TOBIN Consulting Engineers are preparing an Environmental Impact Assessment Report (EIAR) on behalf of Manogate Ltd. for the proposed Ballyfasy Wind Farm in County Kilkenny.

**Re: Scoping Request for the proposed Ballyfasy Wind Farm near Listerlin, Mullinavat, Glenmore and Slieverue, Co. Kilkenny.**

**Re: EIA Scoping Report for the proposed Ballyfasy Wind Farm in County Kilkenny**

Figure 5-2 - Typical Cable Trench Layout in Roadway

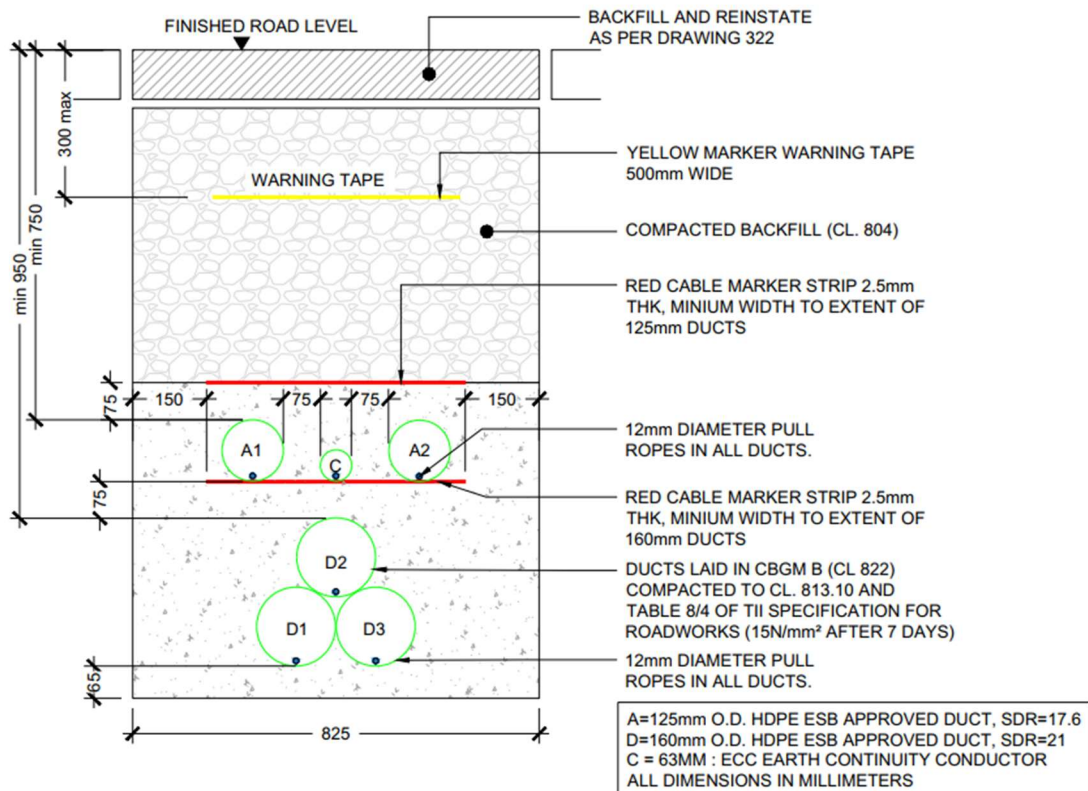
Where the developer proposes the placement of any cables (or additional cables) in one or more trenches within the extents of the (regional and local) public road network, it is necessary to consider the following:

- Their presence within the public road will likely significantly restrict the Road Authority in carrying out its function to construct and maintain the public road and will likely add to the costs of those works.

- Their installation within the lands associated with the public road may affect the stability of the road. In particular where the road is a “legacy road” (where there is no designed road structure and the subgrade may be poor or poorly drained) the design needs to take account of all the variable ground conditions and not be based on a sample of the general soil conditions.

- Details of where within the road cross section cables are to be placed so as to minimise the effect on the Roads Authority in its role of construction and maintenance,

- Elimination of jointing bays from beneath the road pavement to protect the integrity of the road structure for the safety of those driving on the public road by eliminating hard spots and also preserve the road width for other utilities,

4. A condition to require the elimination of jointing bays from under the road pavement to protect the integrity of the road structure, thereby improving safety for those driving on the public road by eliminating hard spots and preserving the road width for other utilities.

Figure 5-6 – Joint Bay and Associated Chambers Arrangement

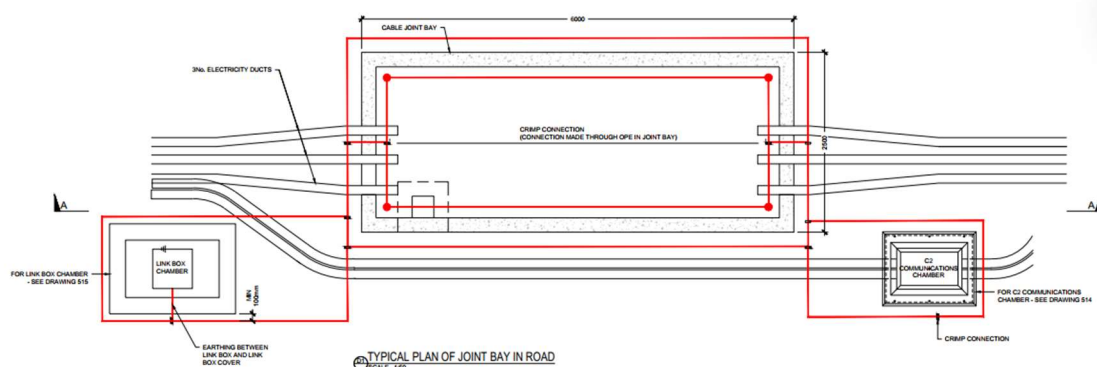
- Examination of details of any chambers proposed within the public road cross section so as to minimise the effect on the Roads Authority in its role of construction and maintenance,

Figure 6-1 – Culvert/ Service Overcrossing

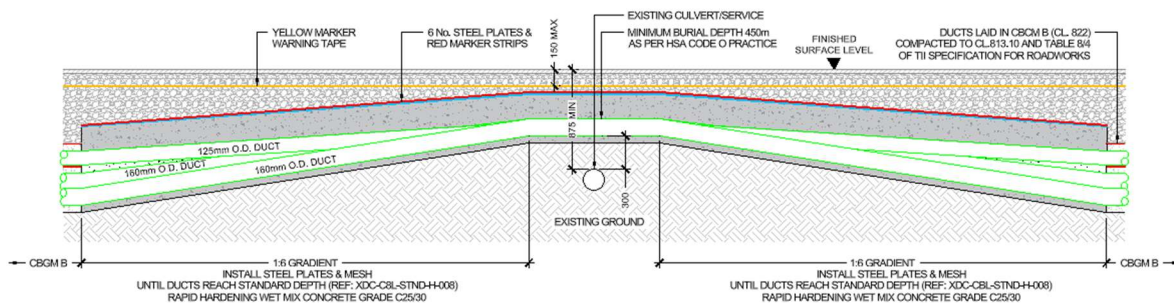
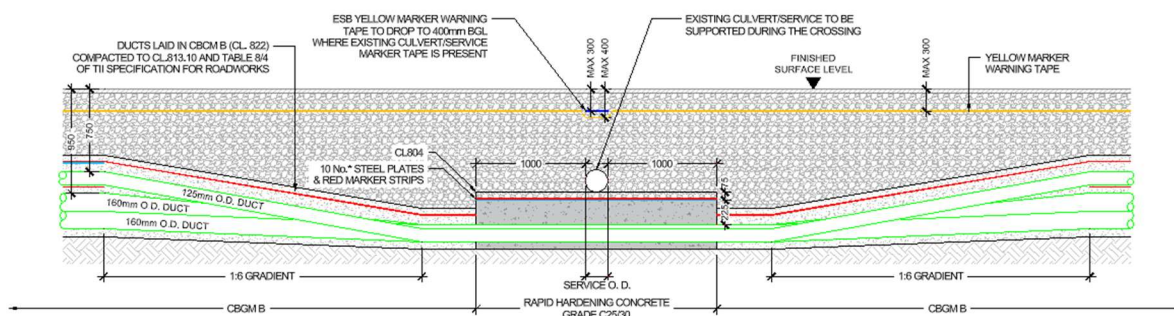
- Prevention of the attachment of cables to all bridge structures and culverts by diverting them beneath or away from these structures and,
- Rationalisation of the number of cables involved (including existing electric or possible future cables) and their diversion into one trench, in order to minimise the impacts on the road network and the environment along the road boundary (hedgerows).

6. A condition requiring the replacement of culverts that have been excavated during the cable duct placement operation. The replacement culverts should be designed appropriately and include an allowance for the effects of climate change.

Figure 2 – Forest areas to be felled for turbines, temporary construction compound, substation, roads and met mast.

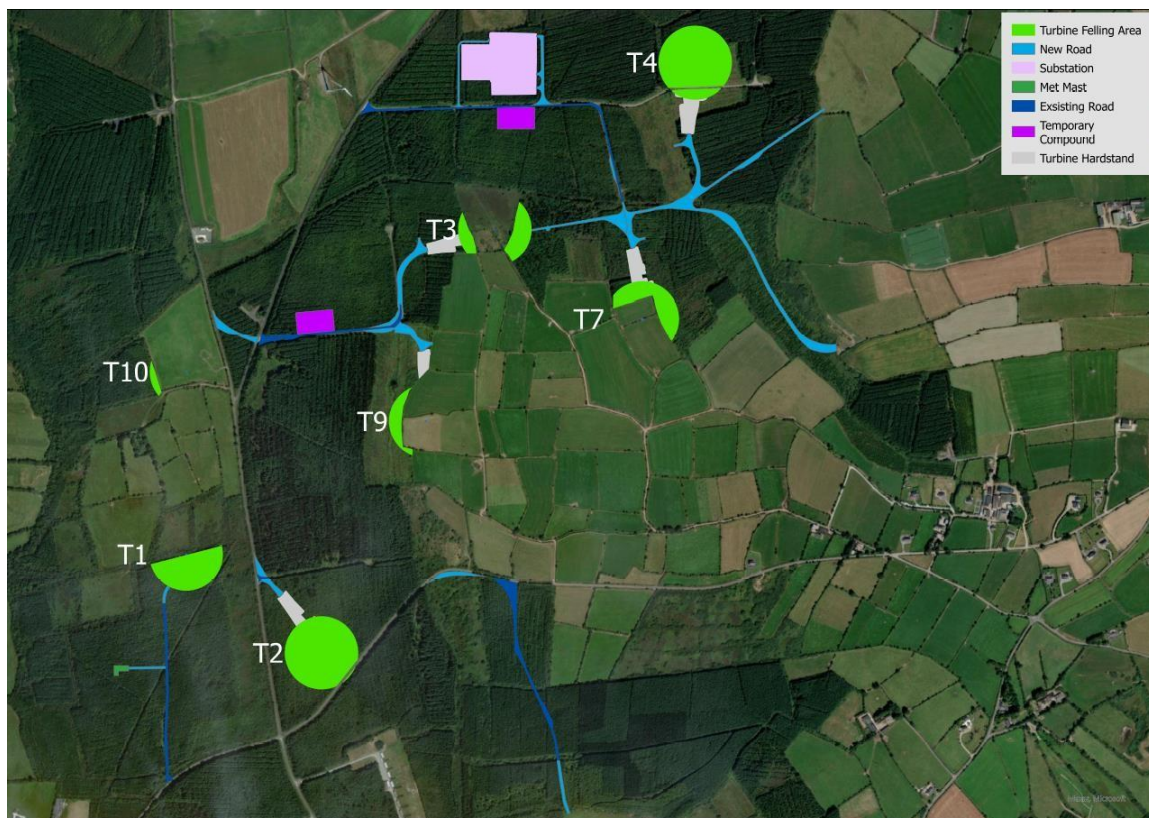
If the proposed development will involve the felling or removal of any trees, the developer must obtain a Felling Licence from this Department before trees are felled or removed. A Felling Licence application form can be obtained from **Felling Section, Department of Agriculture, Food and the Marine, Johnstown Castle Estate, Co. Wexford**. Email: [felling.forests@agriculture.gov.ie](mailto:felling.forests@agriculture.gov.ie) or Web [gov.ie](http://gov.ie) - [www.gov.ie](http://www.gov.ie) - [Tree Felling Licences \(www.gov.ie\)](http://www.gov.ie)

The developer should take note of the contents of **Felling and Reforestation Policy** document which provide a consolidated source of information on the legal and regulatory framework relating to tree felling; [gov.ie](http://gov.ie) - [Tree Felling Licences \(www.gov.ie\)](http://www.gov.ie) As this development is within forest lands, particular attention should be paid to deforestation, turbulence felling and the requirement to afforest alternative lands.

3. Please note that there must be absolute spatial consistency between the felling licence areas submitted to DAFM (second authority) and all related planning documents submitted to the first authority in respect of the felling area(s)
